PLANNING AND INFRASTRUCTURE
Planning Unit

**Re: State Significant Development Application Number SSD-76555711-
Mod-1 for 3-5 Help Street, Chatswood**

Drawing No.
SSDA-1002

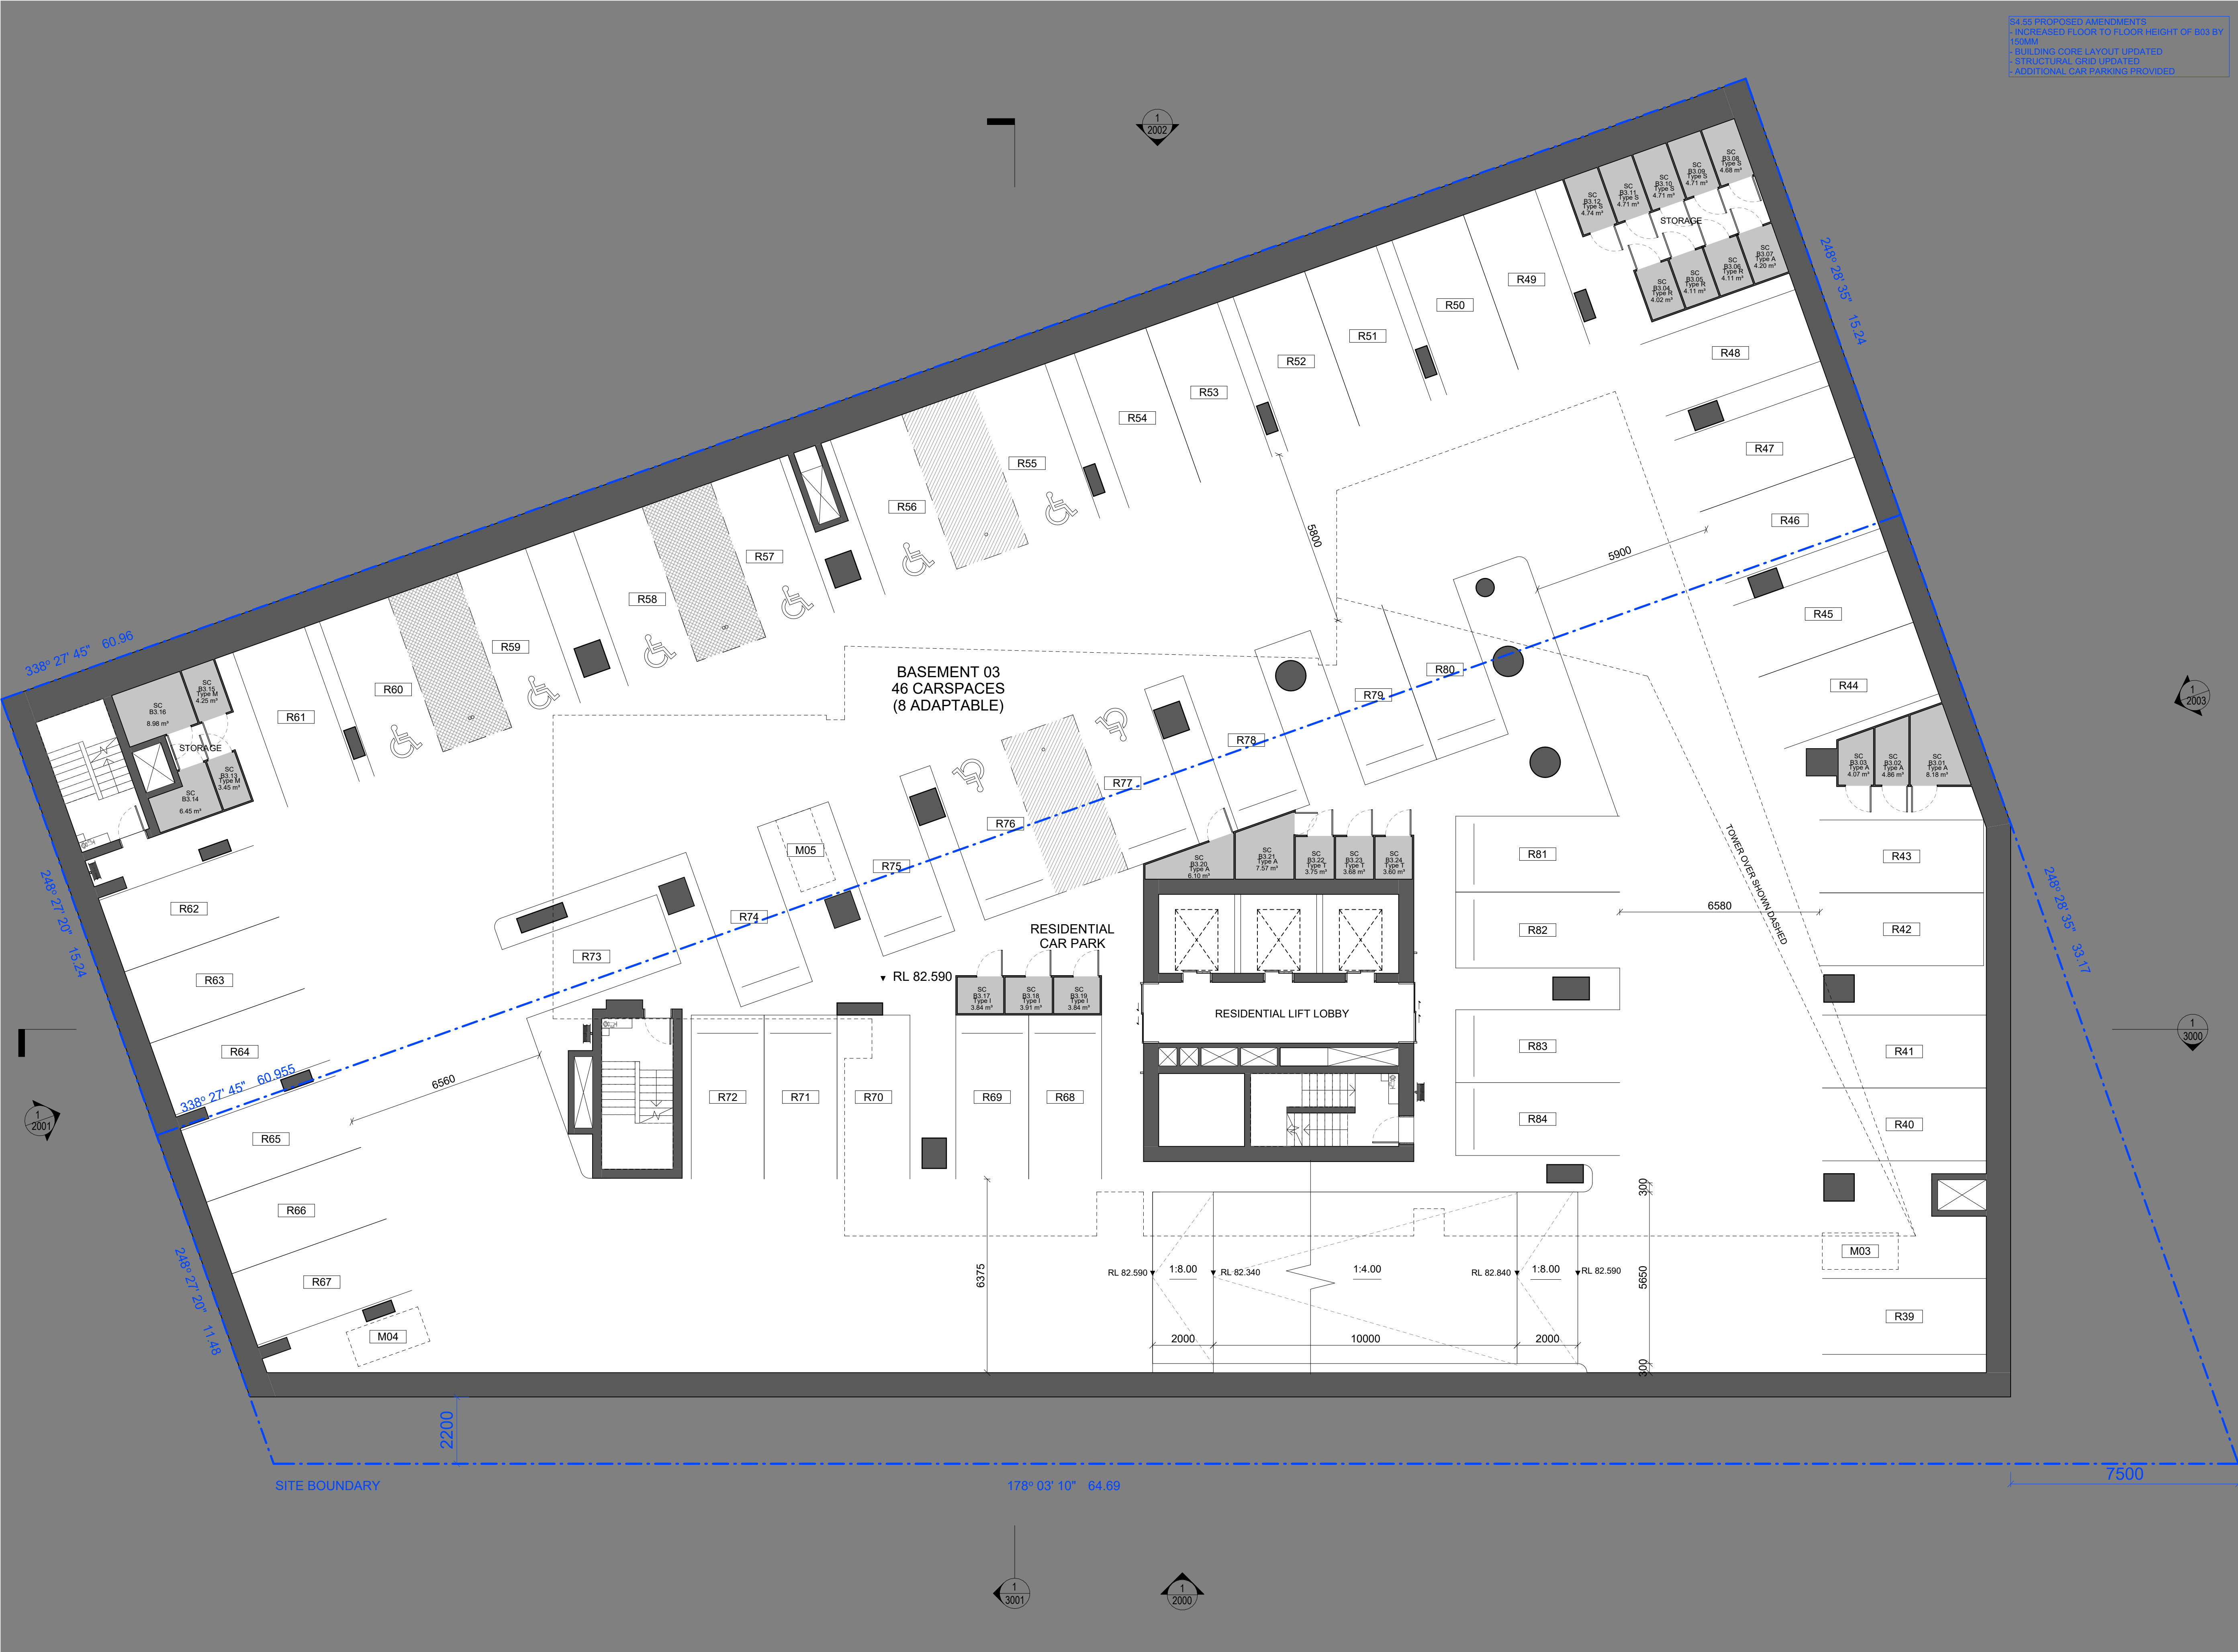
Following a review of the Modification, the increase in number of parking spaces from 166 to 206 car spaces is not supported.

While market and feasibility conditions are acknowledged, they do not justify the systematic overprovision of residential car parking in a location expressly planned to support reduced car ownership. Market feasibility considerations must be balanced against transport planning objectives, observed travel behaviour and broader housing policy objectives, rather than being relied upon as a standalone rationale for oversupply of parking.
